**RE: Family Dollar Store / 4<sup>th</sup> St. NW**  
**Grading Plan and Drainage Report**  
**Stamp Date: 4/6/17**  
**Hydrology File: H14D107**

Based upon the information provided in your submittal received 4/10/2017, the Grading Plan and Drainage Report **is not** approved for Building Permit. The following comments need to be addressed for approval of the above referenced project:

**C-101**

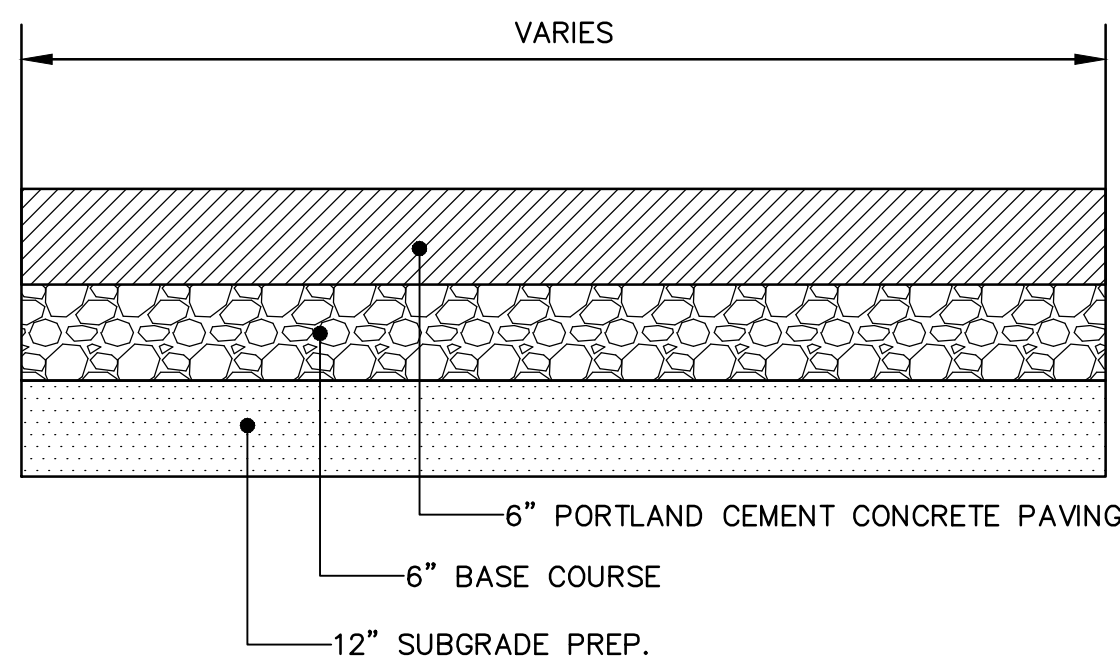
3. Please provide the flowlines for all the proposed concrete channels at both ends (the roof drain and the outfall).
4. Please provide the toe elevations for the proposed rip rap rundown.

5. Under Keyed Notes, #18 the invert elevation is stated as 60.0. However, the existing harvest area has a top elevation is 66.0 and the pond is 3.5 depth, so shouldn't the invert elevation be shown as 62.5 instead of 60.0?

6. Under Keyed Notes, there are two #18s. Please renumber the last five numbers and also change the corresponding numbers on the plan.
7. Please provide the flowline elevation of the start of the proposed valley gutter.

8. Please provide the existing flowline elevation of the existing concrete channel where the proposed valley gutter will connect.
9. Please provide the TC & TA for the corner of the proposed parking near the existing concrete rundown.

10. It appears that the above proposed parking corner is over the existing concrete rundown. If this parking spot is needed, then the existing concrete rundown will have to be replaced or relocated to avoid the construction conflict. Please clarify.

11. Please provide the top and bottom elevation on the shown contours of the existing water harvest basin.
